# CITY OF ALBUQUERQUE

RE: **Jiffy Lube Expansion**  
**8305-8313 Menaul NE**  
**Grading Plan Stamp Date: 9/4/19**  
**Drainage Report Stamp Date: 9/4/19**  
**Hydrology File: H15D068**

Based on the submittal received on 9/4/19, this project cannot be approved for Plat or Building Permit until the following are corrected:

ENGINEER'S SEAL	ENGINEER: JIFFY LUBE	DRAWN BY: BF
		8305 MENAUL BLVD. NE	DATE: 11/6/2019
		TRAFFIC CIRCULATION LAYOUT PLAN	2018016_TLC
		TIERRA WEST, LLC 5571 MIDWAY PARK PLACE NE ALBUQUERQUE, NM 87109 (505) 858-3100 www.tierrawestllc.com	SHEET # C1 JOB # 2018016

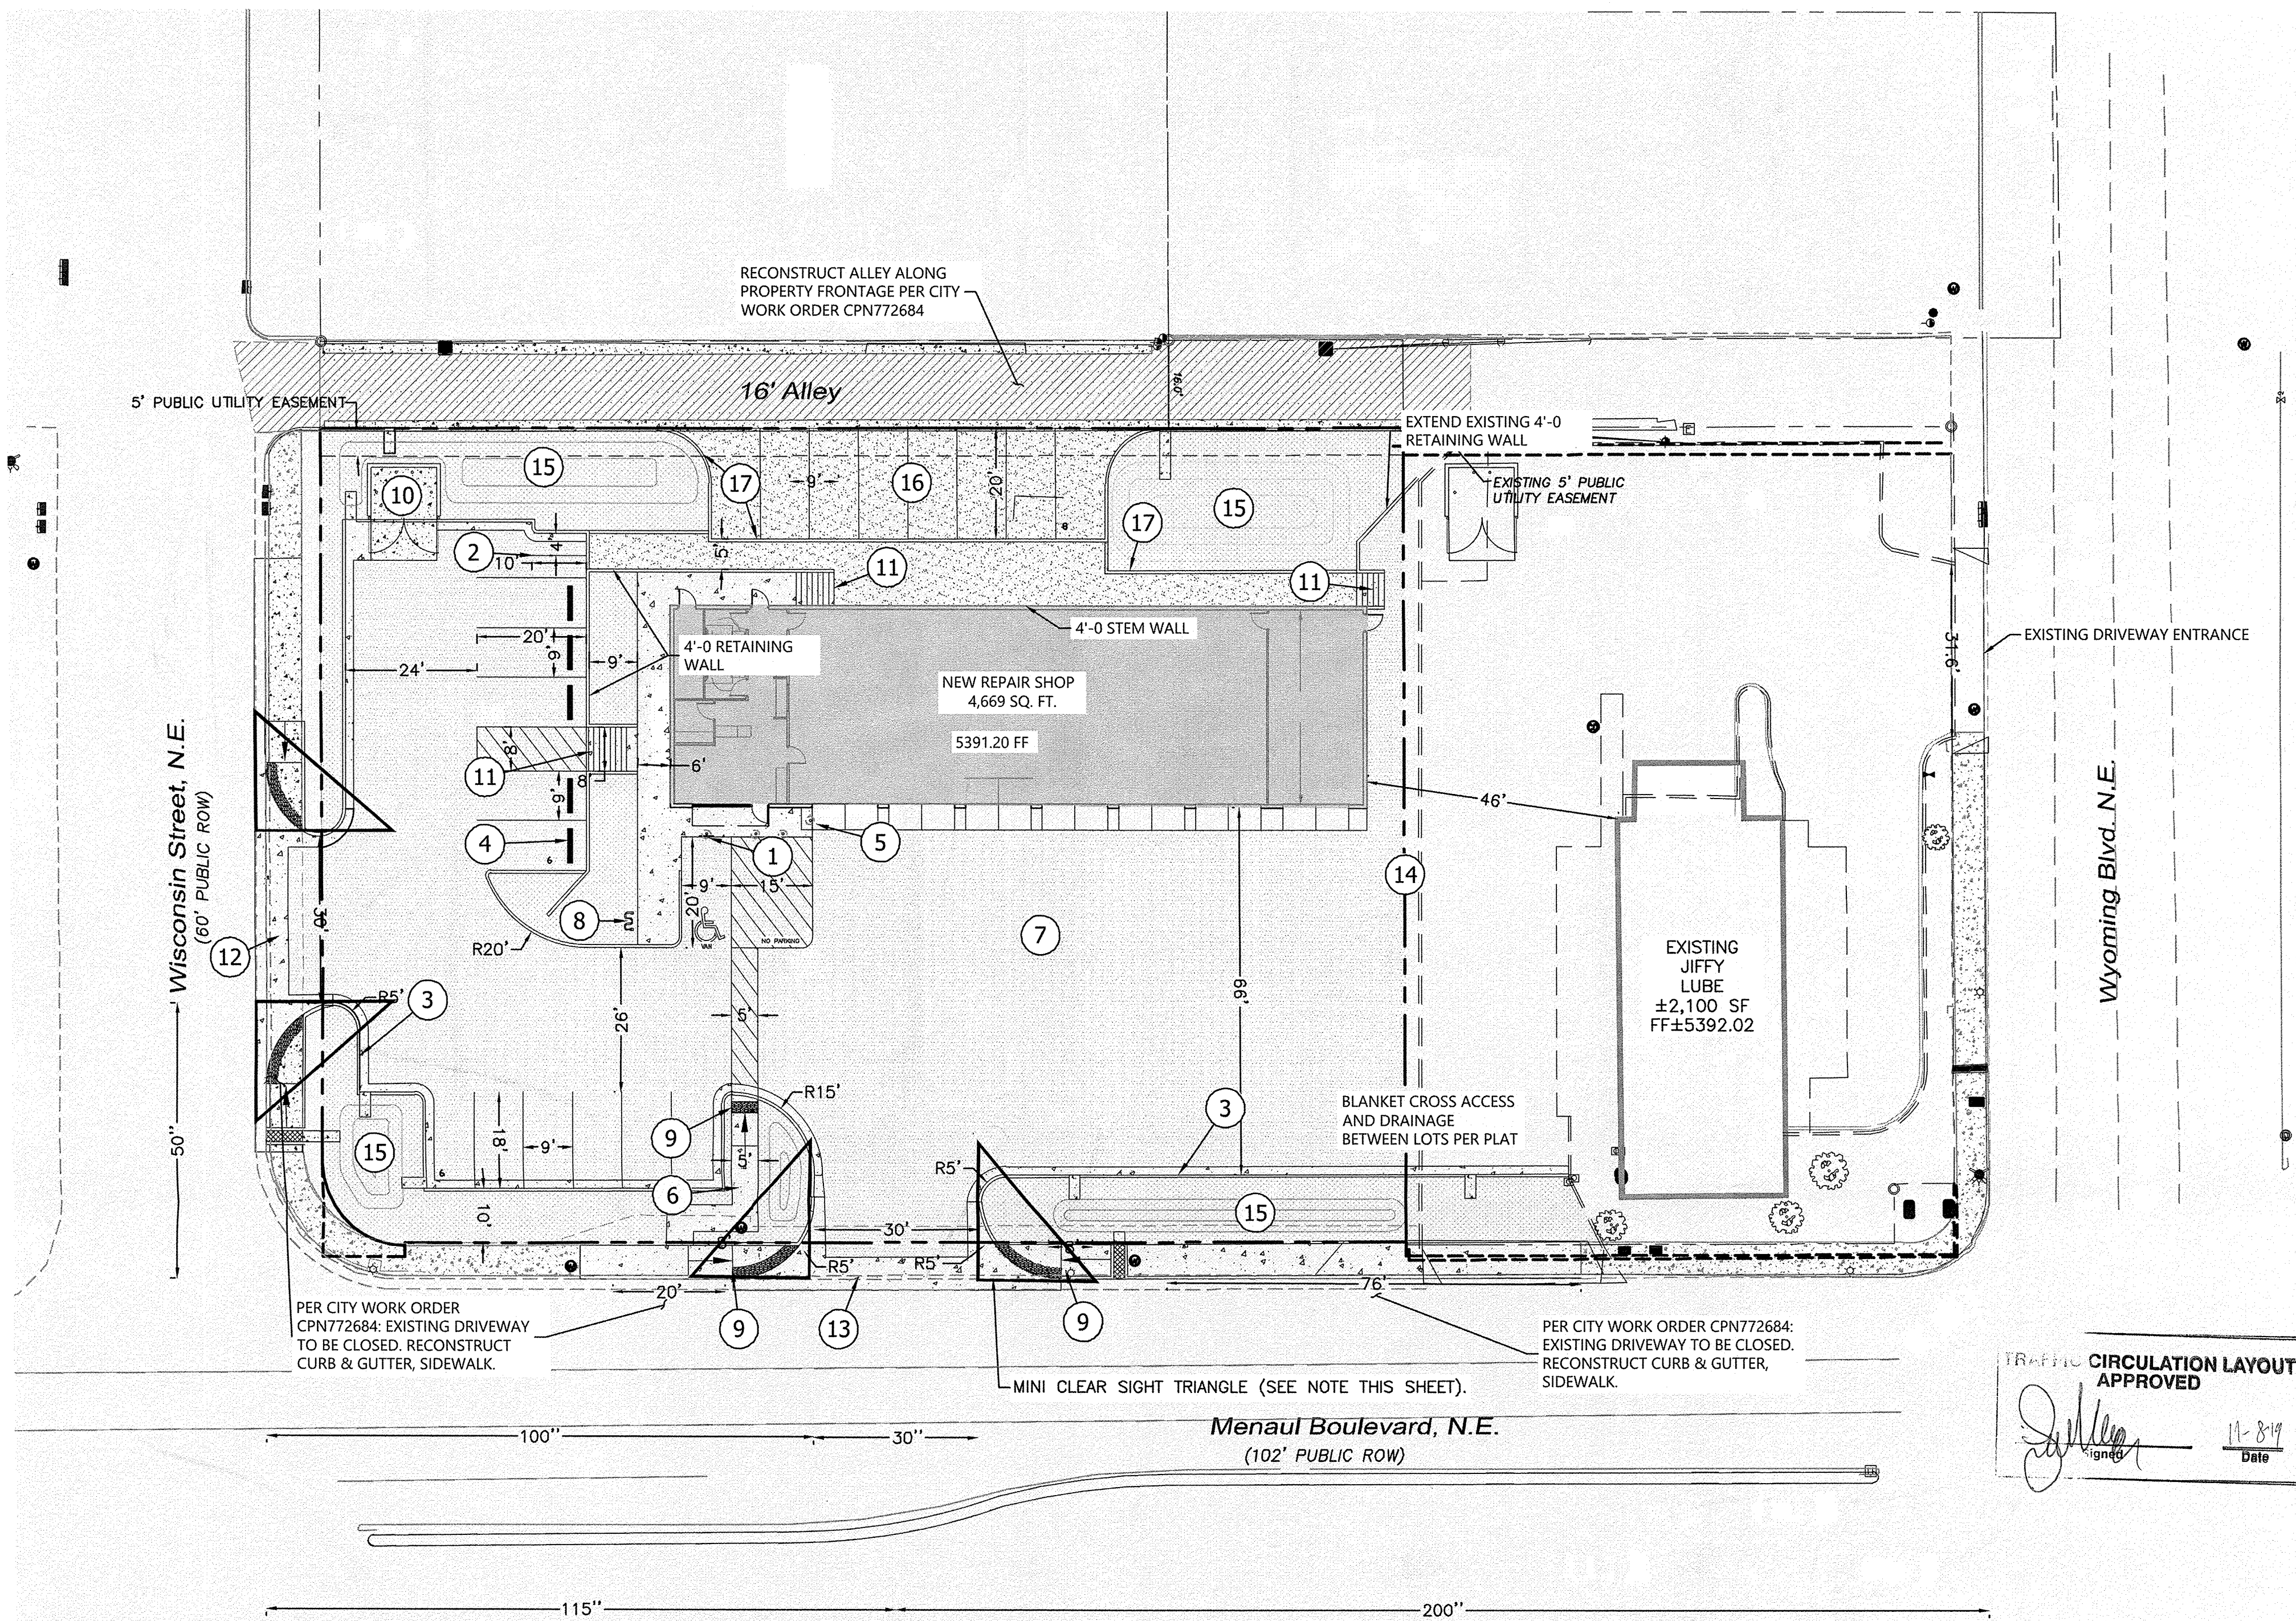
1. Remove the SO-19 notes (C1).
2. List the sidewalk culverts on the infrastructure list.
3. On the Plat, provide a drainage easement over the ponds and annotate using the [Plat Drainage Easement Note](#). This note replaces the need for a separate drainage covenant (alternatively, you could do a drainage covenant, recorded prior to C.O).
4. For automotive repair centers, demonstrate *control of oil from vehicle parking areas* per DPM Chapter 22.9.E, Table 1. SWQPs 1, 3, and 4 will need outlet structures designed to trap oil during the 100-yr and smaller storms. Ideas may include a 90<sup>0</sup> downturned pipe elbow or steel plate skimmer around the back of the sidewalk culvert. SWQP 2 is fine since it doesn't serve any parking area.
